SSD-71457960 | Yorktown Parade and Fitzgerald Avenue, Maroubra - Affordable Housing Redevelopment

1. We act for The Owners - Strata Plan 90056 at 189 Fitzgerald Avenue Maroubra, NSW 2035 (our **client**) and refer to the State Significant Development Application, SSD-71457960 (the **SSD**) at 195-213 Fitzgerald Avenue and 40-64 Yorktown Parade, Maroubra (the **Site**).

DWG No. LSK-01

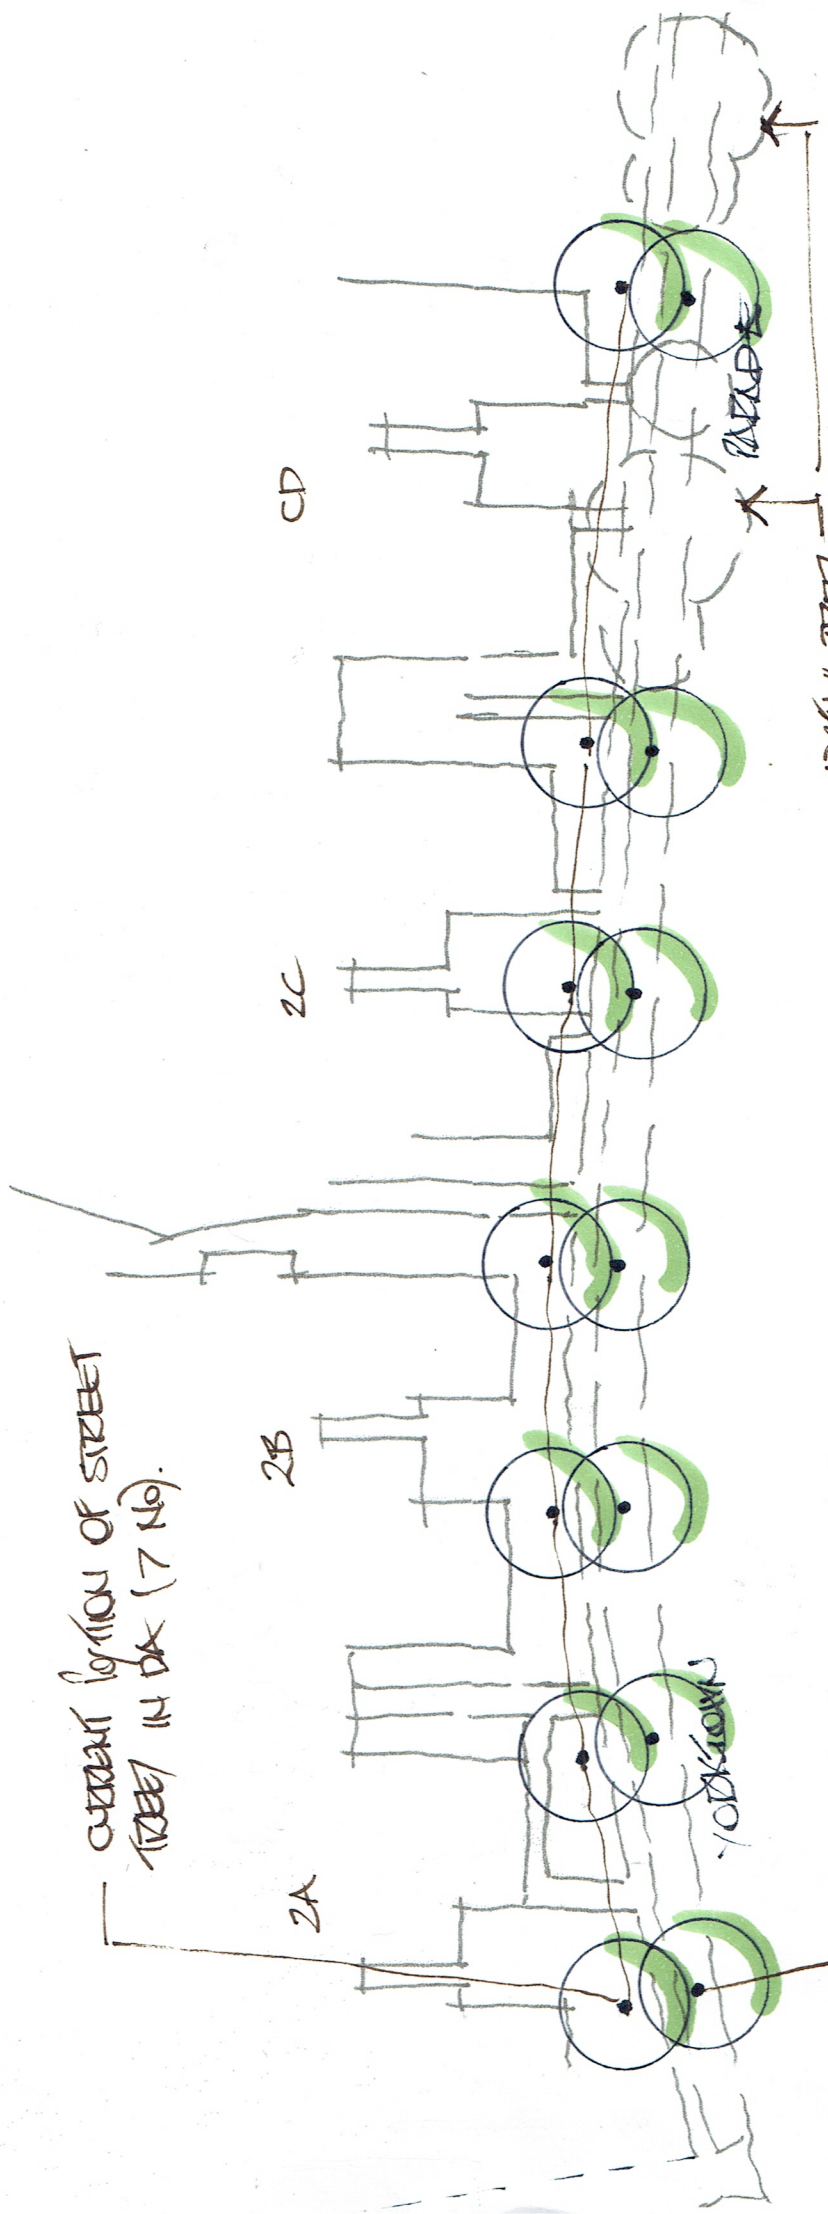
31. We appreciate that a BDAR waiver was granted by DPHI on 21 October 2024 however we refer to the numerous references to the EIS at section 7.9 which incorrectly states that the *"proposal includes the retention and protection of all trees within Fitzgerald Avenue and Yorktown Parade, and the removal of 122 trees on the Site"*. This is again reinforced throughout the EIS at section 7.5.1.
32. This appears to be an incorrect statement as evidenced by the Landscape and arboricultural plans which show that Trees 82, 86 are located outside the site boundary and are proposed to be removed.

33. There is a discrepancy between the landscape and arboricultural plans which identify that several trees are in fact not within the site boundary. Specifically tree T76 and T77 are

located on the site boundary on the arboricultural report but are located outside the site boundary in the landscape report.

34. The impact upon the locality cannot be properly assessed without accurate identification of the location of the trees. If street trees are not maintained the characteristics of the street will be altered. Further, we have not been made aware of Council's agreement to any of the trees being removed in circumstances where there is conjecture as to what trees will be retained.
35. Clarification on the exact location of trees should be undertaken to ensure that during construction trees are not incorrectly removed.

45. The proposed driveway and basement design concentrates access to the development at one point on Fitzgerald Avenue. The SSD site is bounded by ANZAC Parade (a major arterial road) and Malabar Road. There are driveways to the adjoining properties directly next to the proposed driveway, intensifying the traffic flows along Fitzgerald avenue.
